Subject: RE: Planning Consultation on: A/266/21/PL

Further Engineers Comments Regarding Surface Water Drainage

Engineers Comments Regarding Surface Water Drainage

Site Address: Crete House The Beeches Dappers Lane Angmering BN16 4EN

SITE PLAN & VISIBILITY SPLAY
1:200

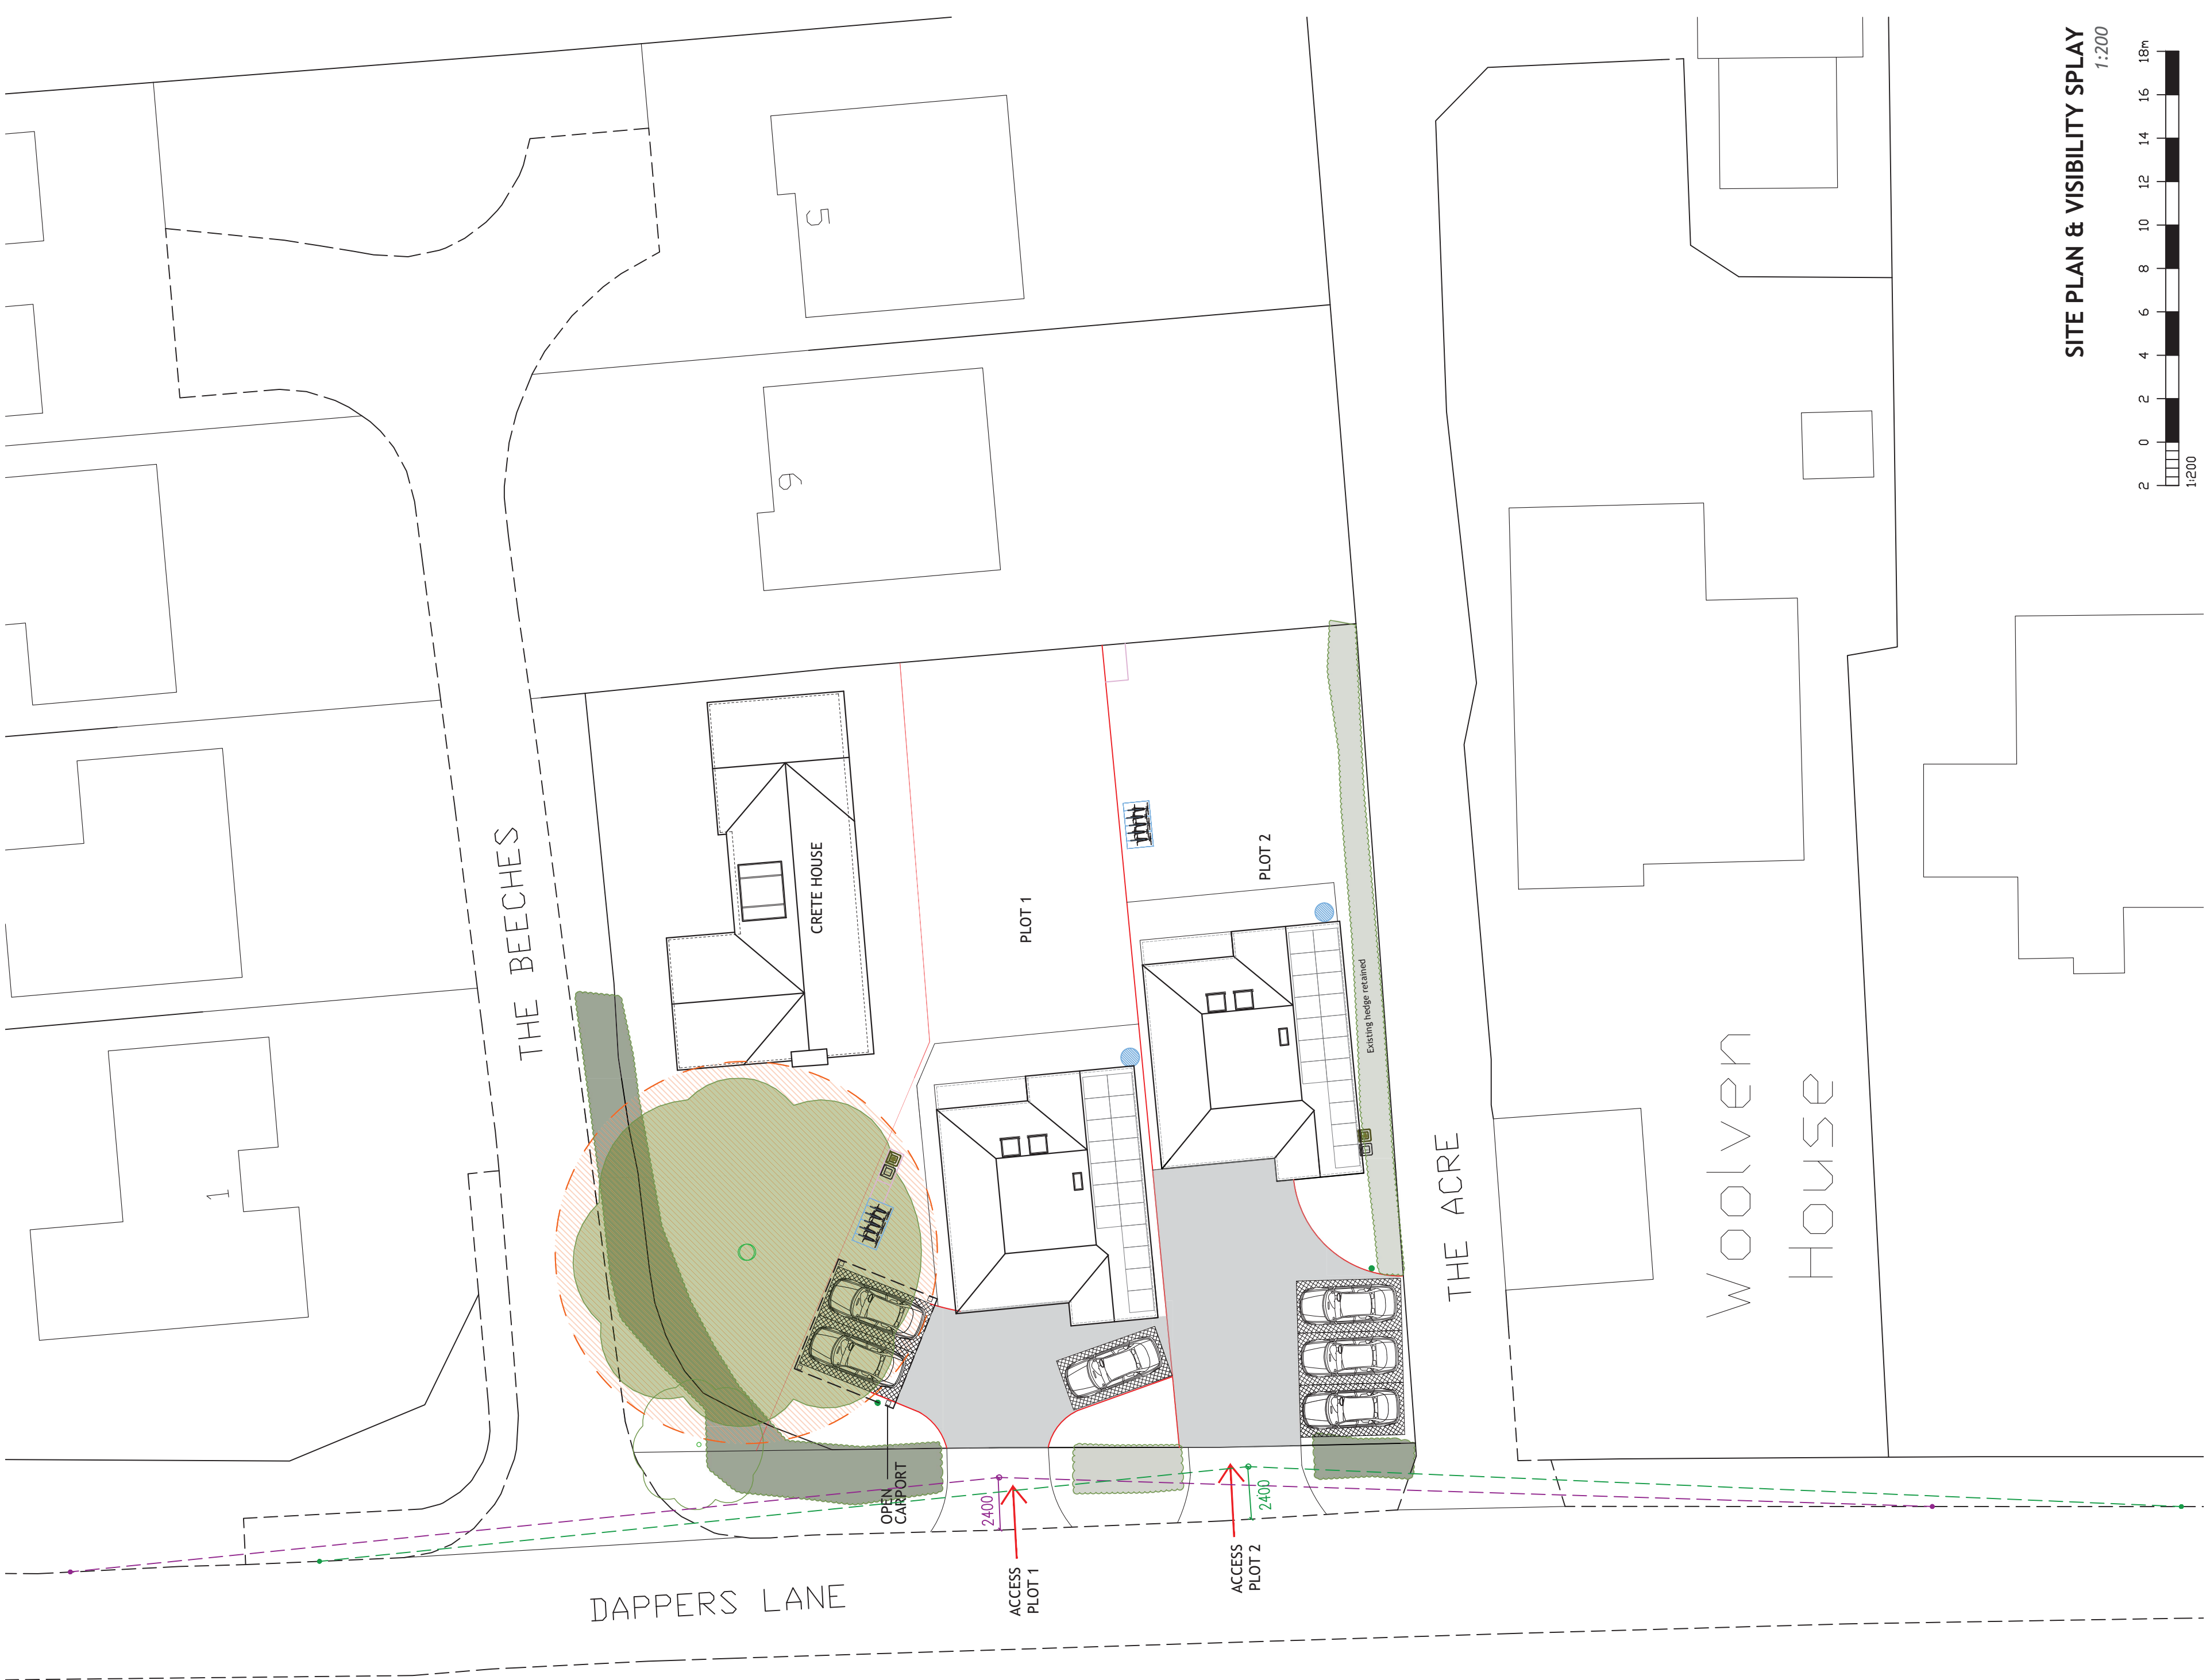
No flood risk assessment (FRA) or drainage design has been provided to support this application. Much of the site is at risk of surface water flooding, with an area in the location of the proposed house for Plot 2 at risk of surface water flooding in a 1 in 100 year storm event (with no allowance for climate change). Paragraph 167 of the National Planning Policy Framework states that local planning authorities should ensure that flood risk is not increased as a result of a proposed development. Footnote 55 states that in "flood zone 1 an assessment should accompany all proposals involving (...) land that may be subject to other sources of flooding, where its development would introduce a more vulnerable use." The introduction of two new dwellings in an area which was formerly a garden will introduce a more vulnerable use and will be in an area subject to other sources of flooding (surface water).

Therefore I wish to lodge a holding objection to this application. To overcome my objection the applicant should provide an FRA that takes account of the surface water flood risk on the site and shows that flood risk will not be increased on or offsite as a result of the proposed development. If the site layout is to remain unchanged then compensatory storage for the lost surface water flood area may need to be provided.

If the FRA is provided and is satisfactory then the applicant should be aware that the proposed new dwellings have adequate space for containing a soakaways in their rear gardens. However, the proposed development will likely disrupt the existing surface water drainage for Crete House. Therefore we would expect to see a surface water design for the whole site, including the extended Crete House. The surface water drainage for Crete House will likely need to be located to the north of the house under the driveway as existing and proposed trees (root protection zones) must not conflict with suds features/pipework.
